Date: May 14, 2025

Re: 23-KAHD-002.1.2
Brick Lintel Installation and Deviations
Fleming Residence
354 Pointer Creek Drive
Angier, NC 27501

At your request, the plans and provided information were reviewed for the above referenced single family residence under construction to address the brick lintel installation and plan deviations.

FRONT ELEVATION

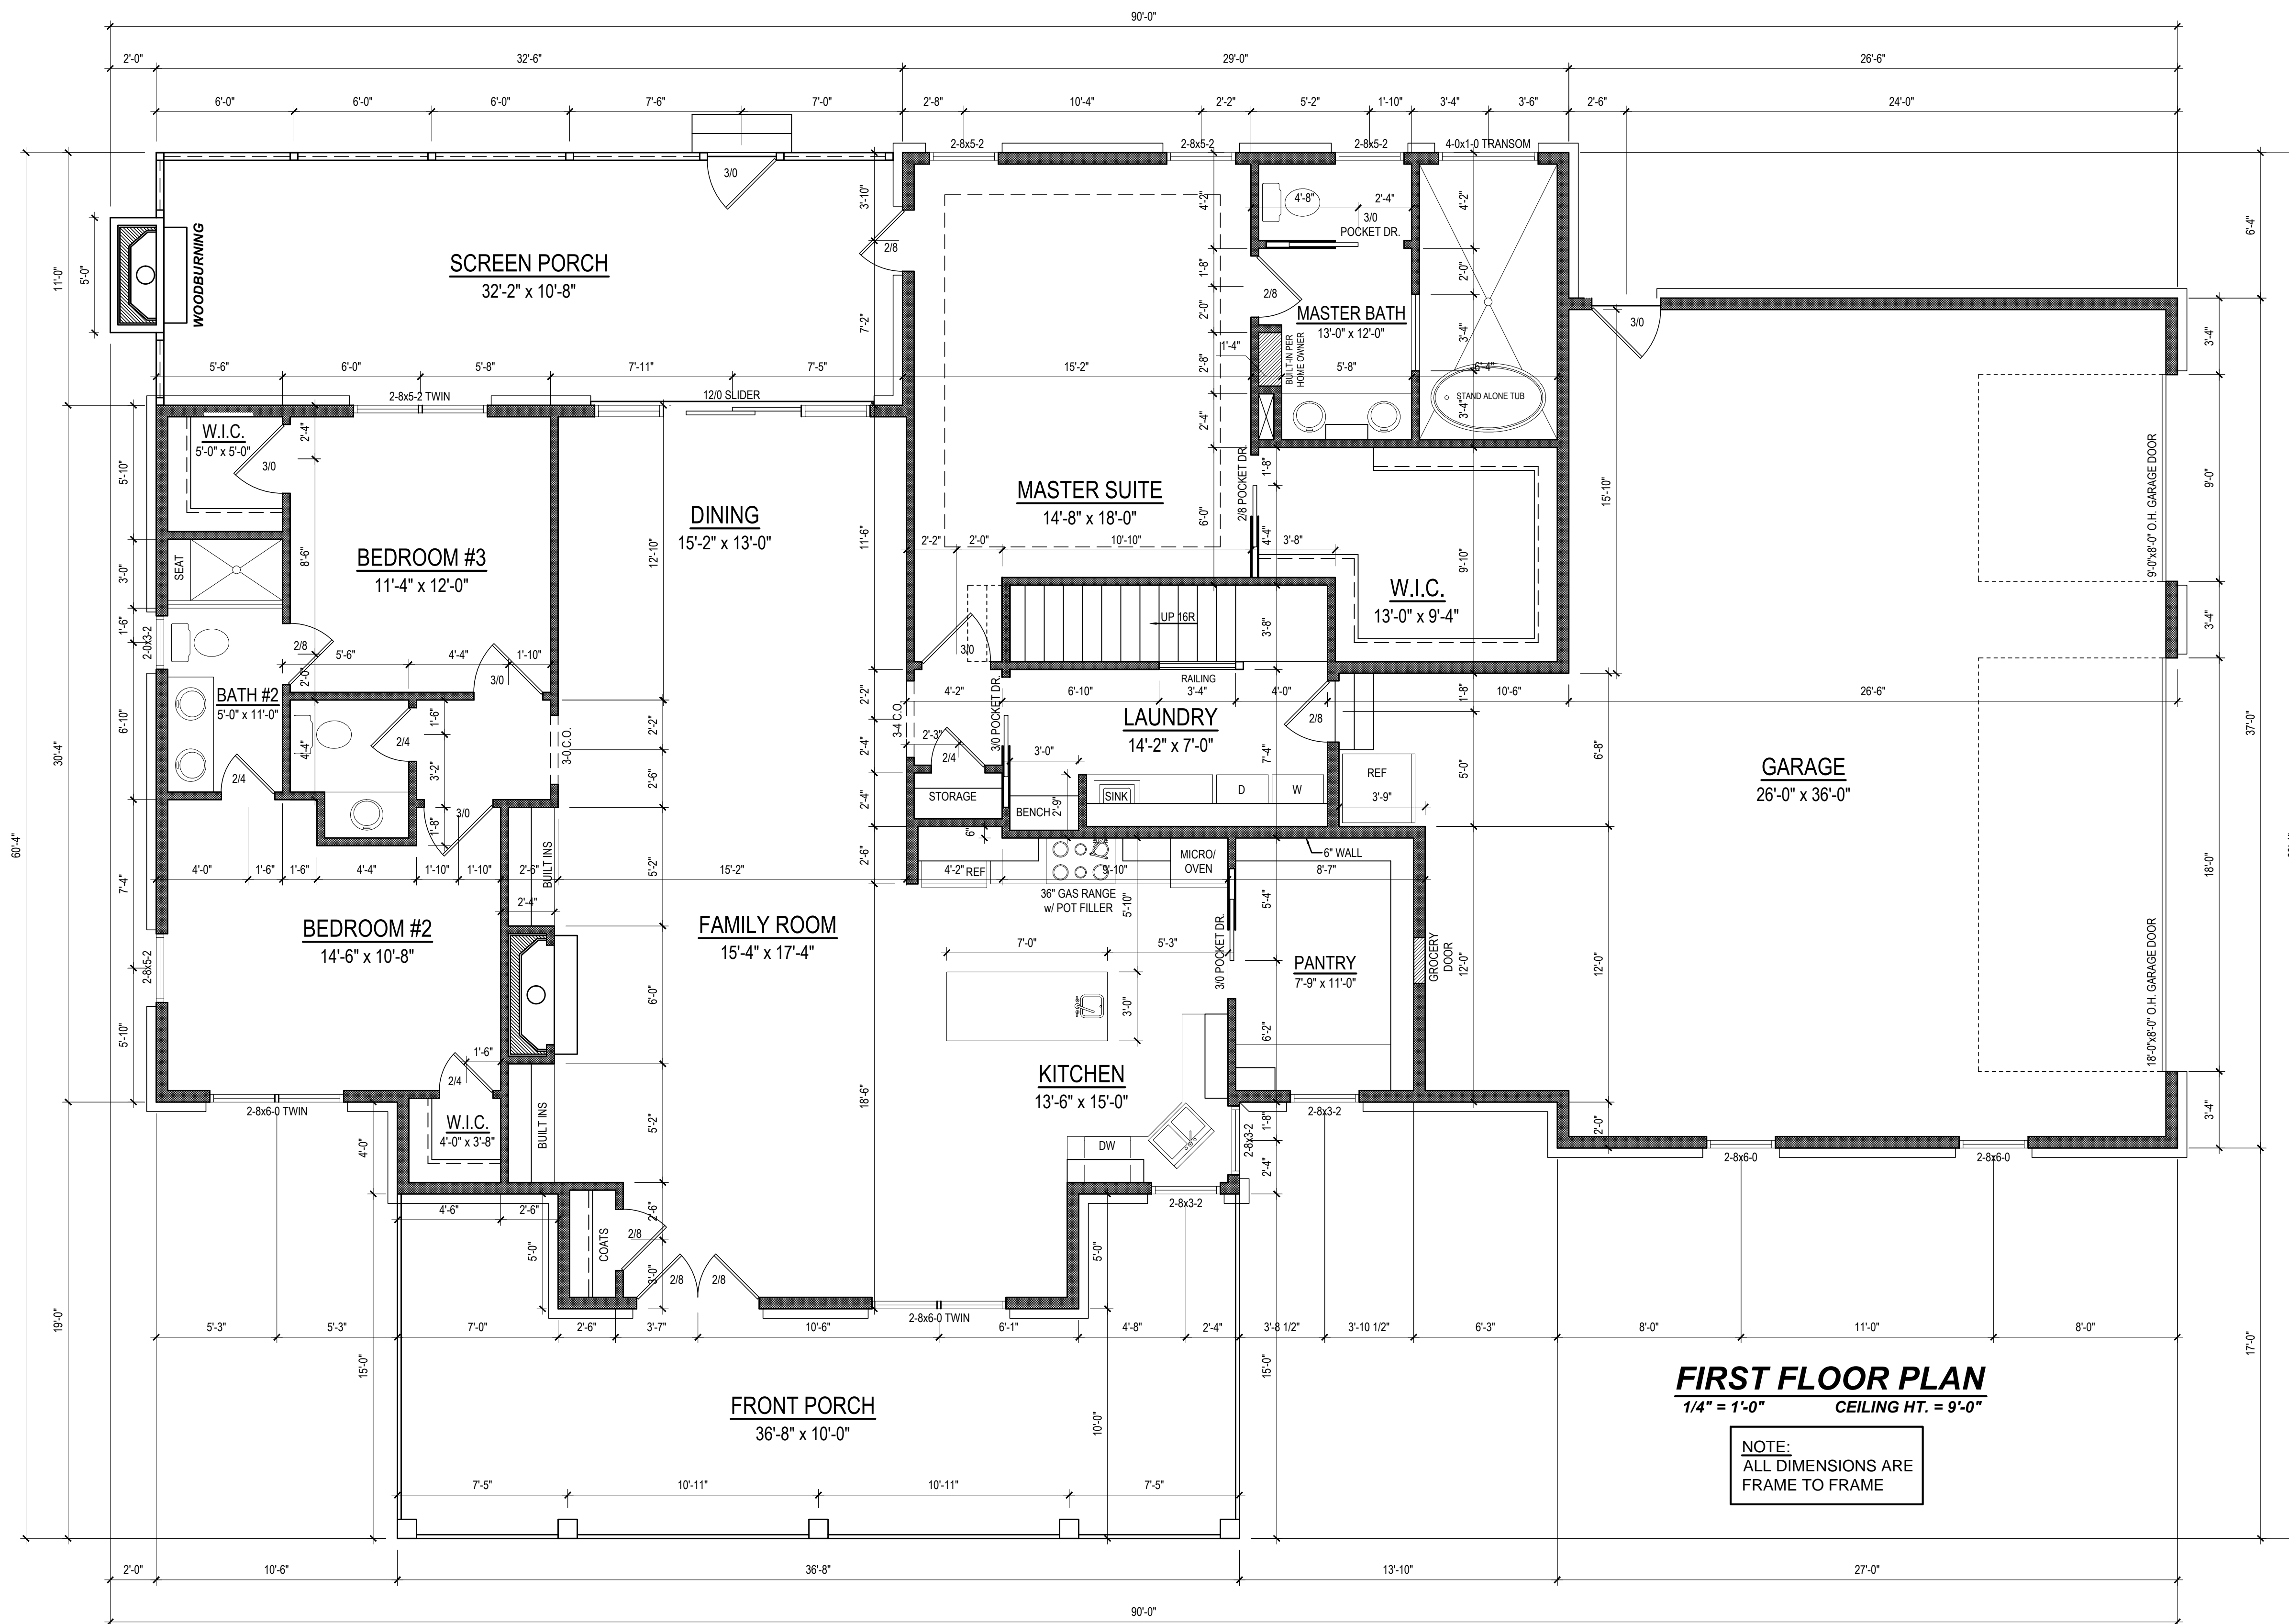
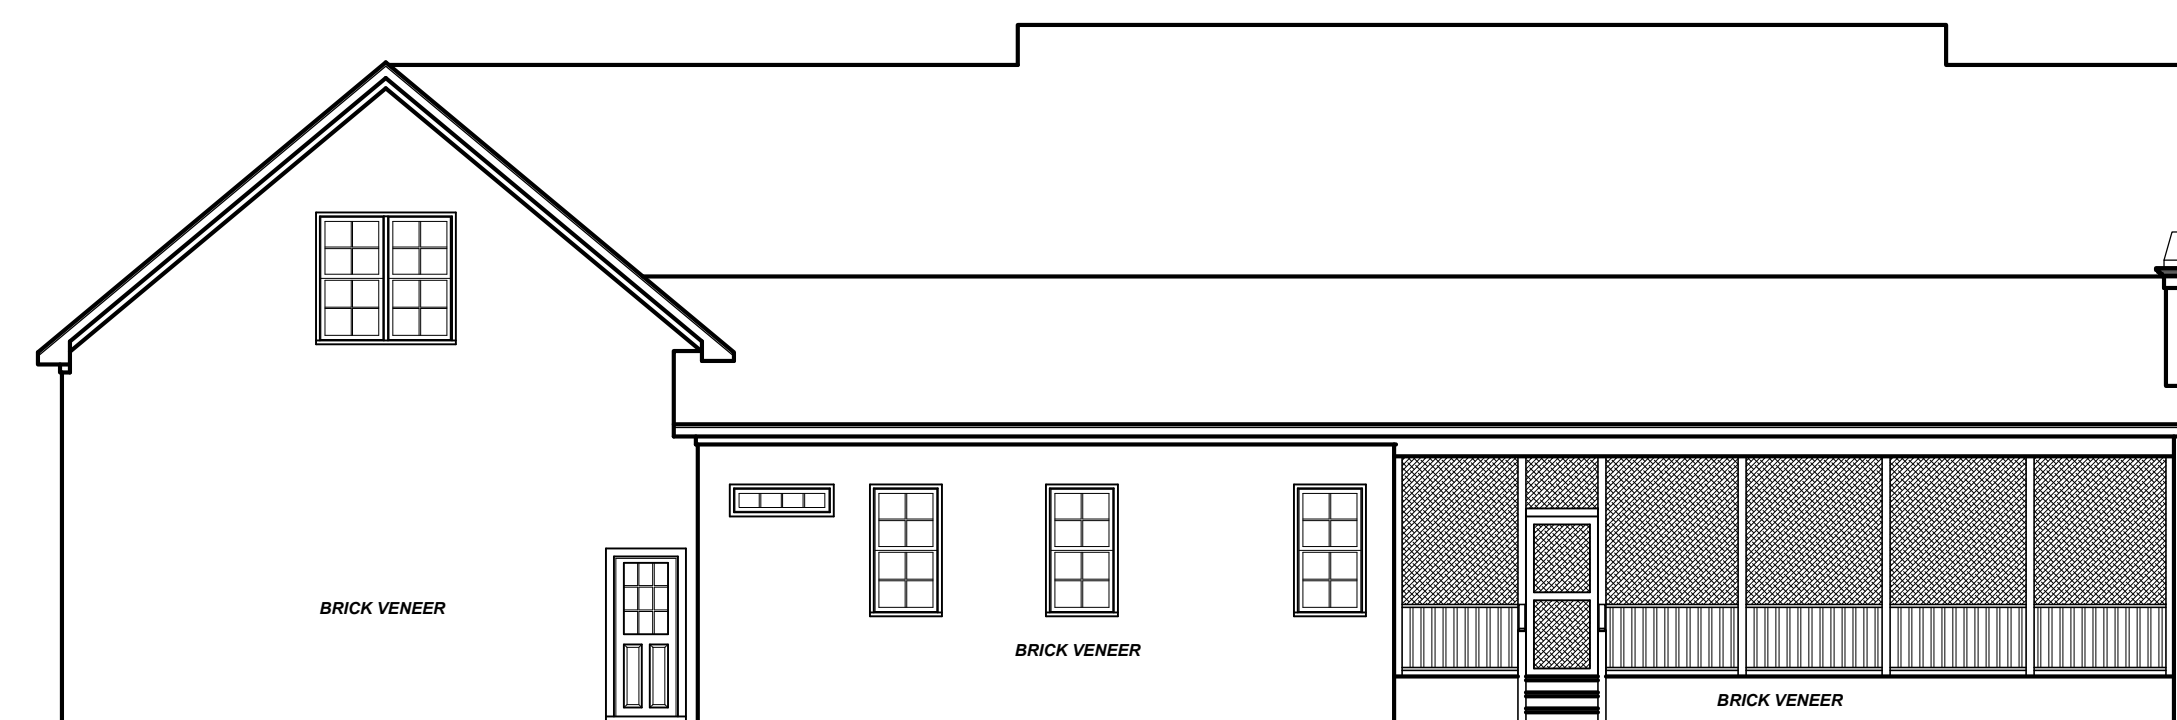
3. You indicated a triple 2/8 window unit was installed within the front exterior wall of the garage per the front elevation in lieu of two individual windows per the first floor plan. You indicated a (3) $1\frac{3}{4}$ "x11 $\frac{7}{8}$ " LVL header was installed above the window opening.

3. Analysis revealed the (3) $1\frac{3}{4}$ "x11 $\frac{7}{8}$ " LVL header is suitable to support the loading above the triple 2/8 window opening. The header is to be supported by a minimum of (2) 2x6 jack studs and (3) king studs at each end. An L5x3 $\frac{1}{2}$ x5/16 steel angle with the long leg placed vertically is to be installed above the window opening to support the brick veneer above. The steel angle is to be embedded a minimum of 4" into the brick veneer at each side of the opening.

FIRST FLOOR PLAN
 1/4" = 1'-0" CEILING HT. = 9'-0"

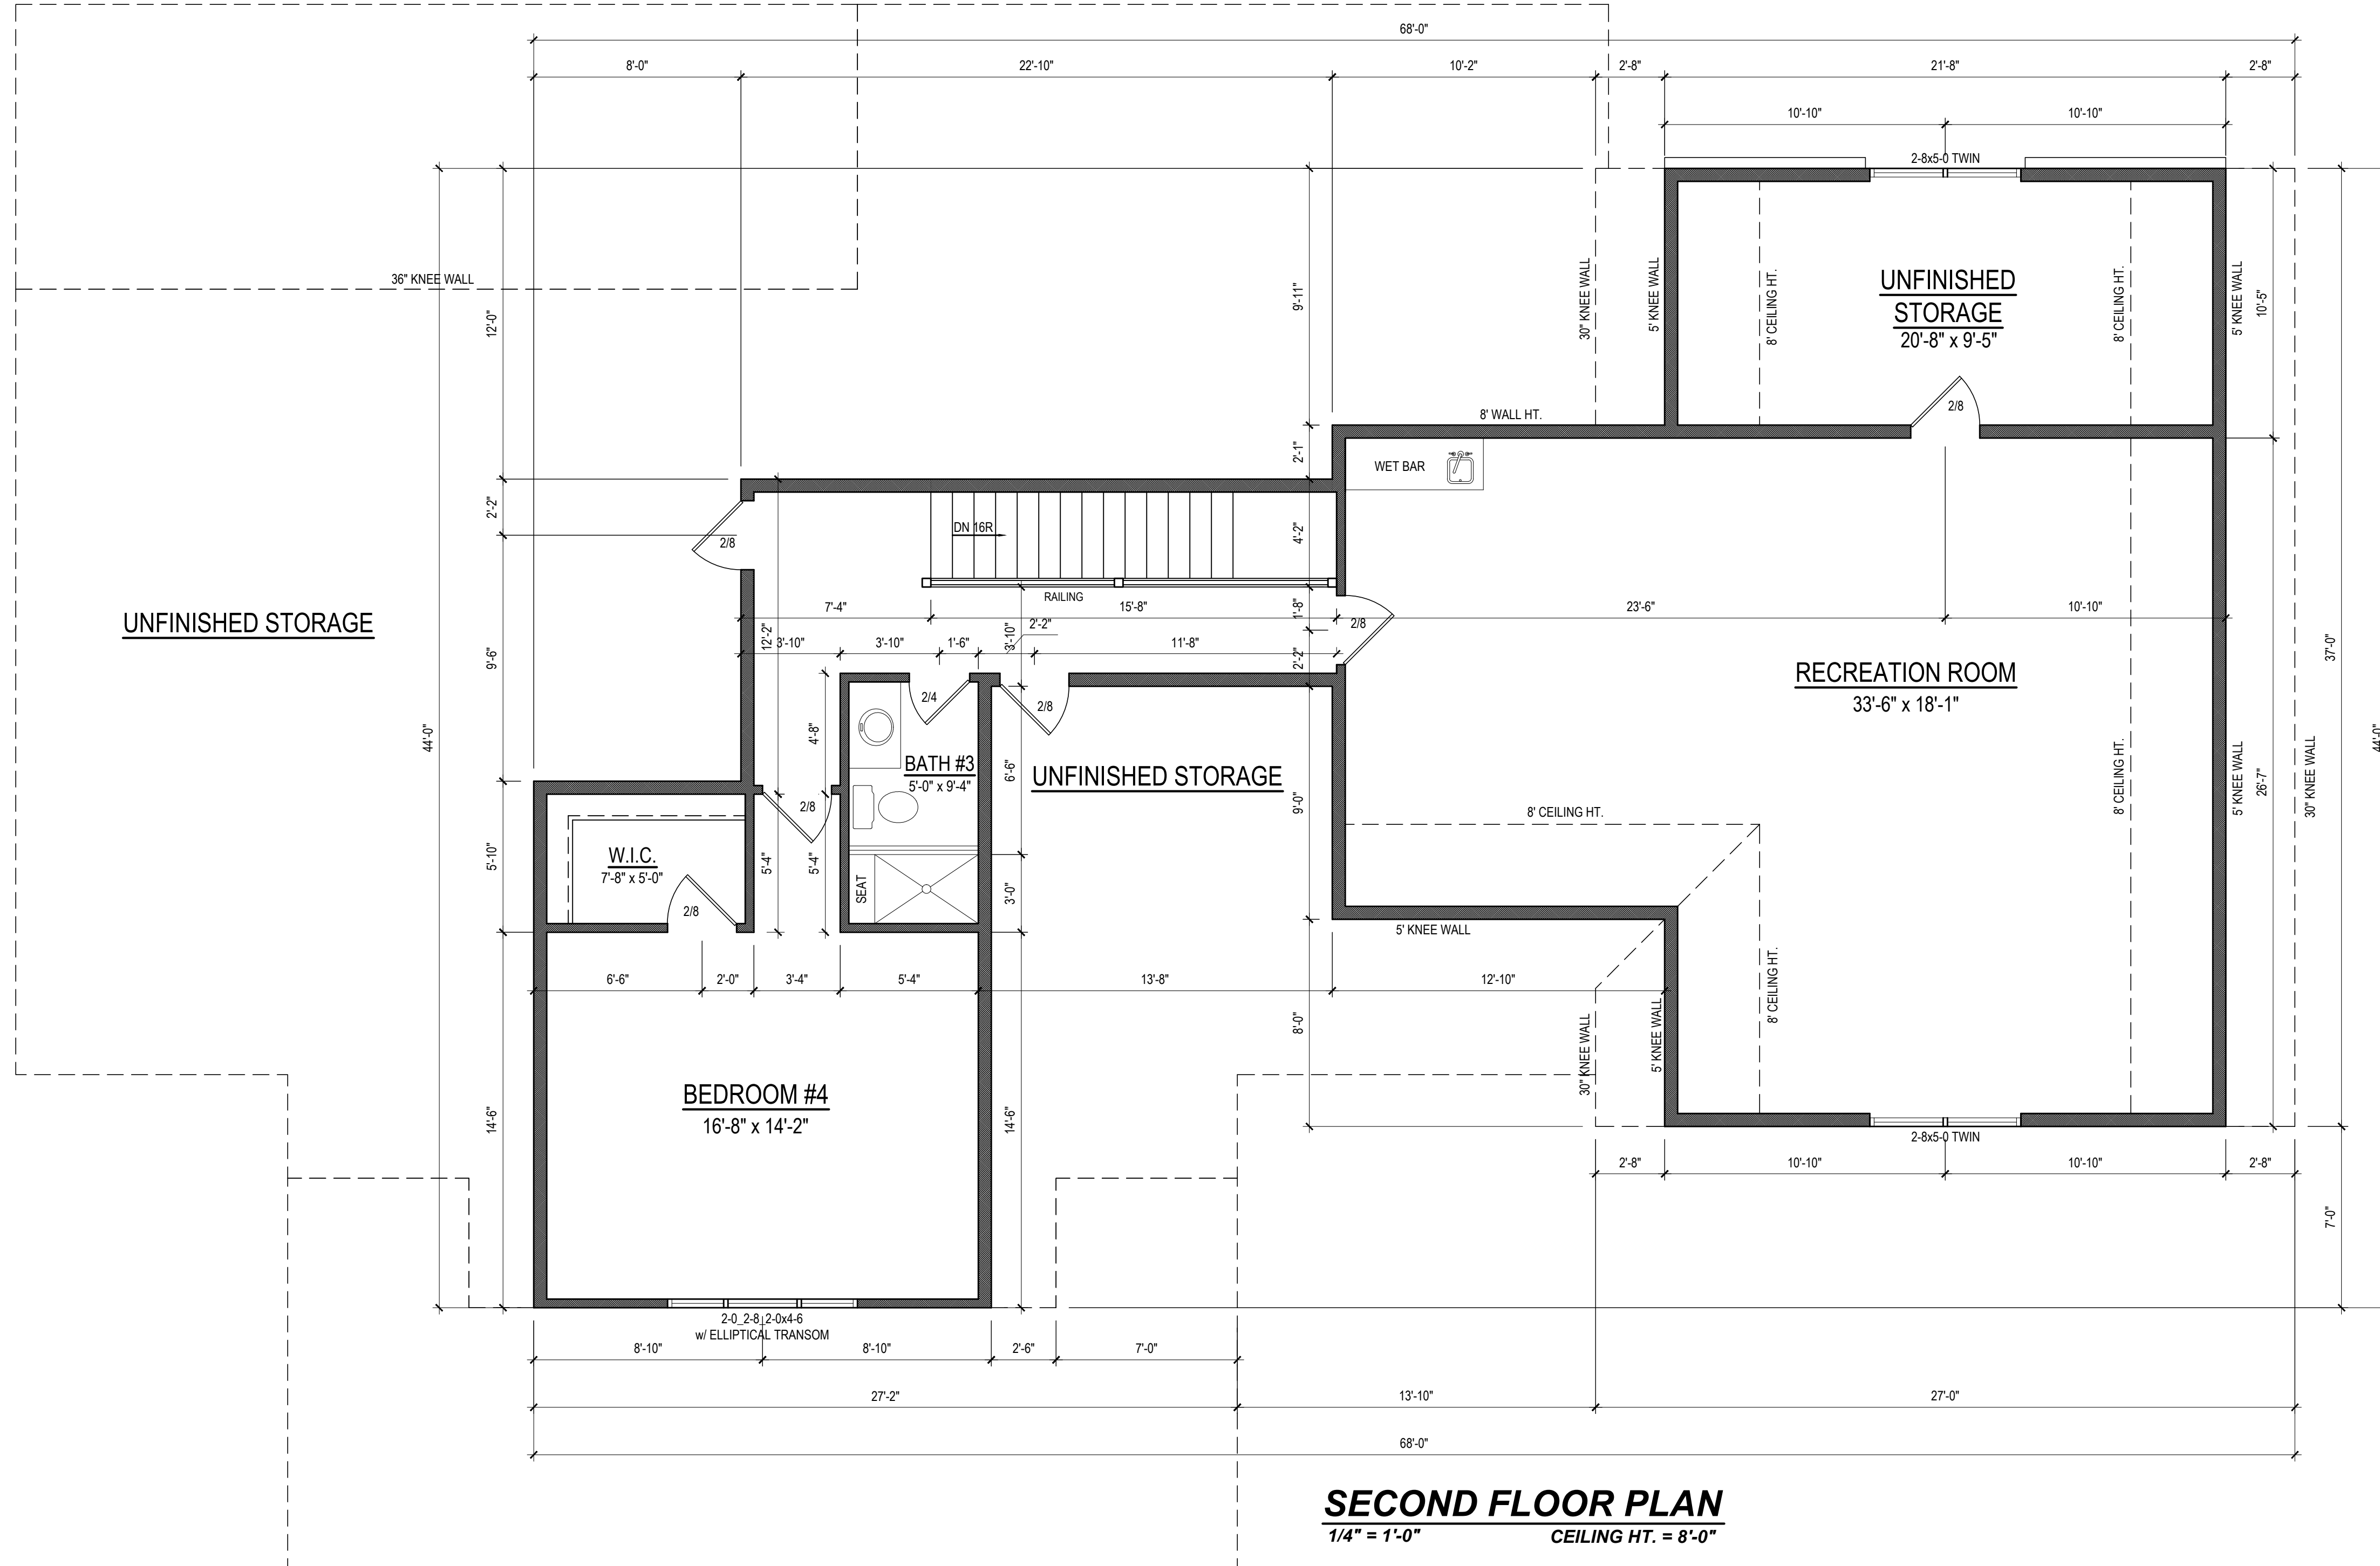
4. You indicated the headers above the 3/0 garage service door and 3/0 door between the master bedroom and screen porch are braced by (1) king stud at each end. You indicated the rough openings measure +/- 38" in width.

4. Analysis revealed (1) king stud is suitable to brace each end of the headers above the +/- 38" rough openings for the garage service door and door between the master bedroom and screen porch. Additional king studs are not required.
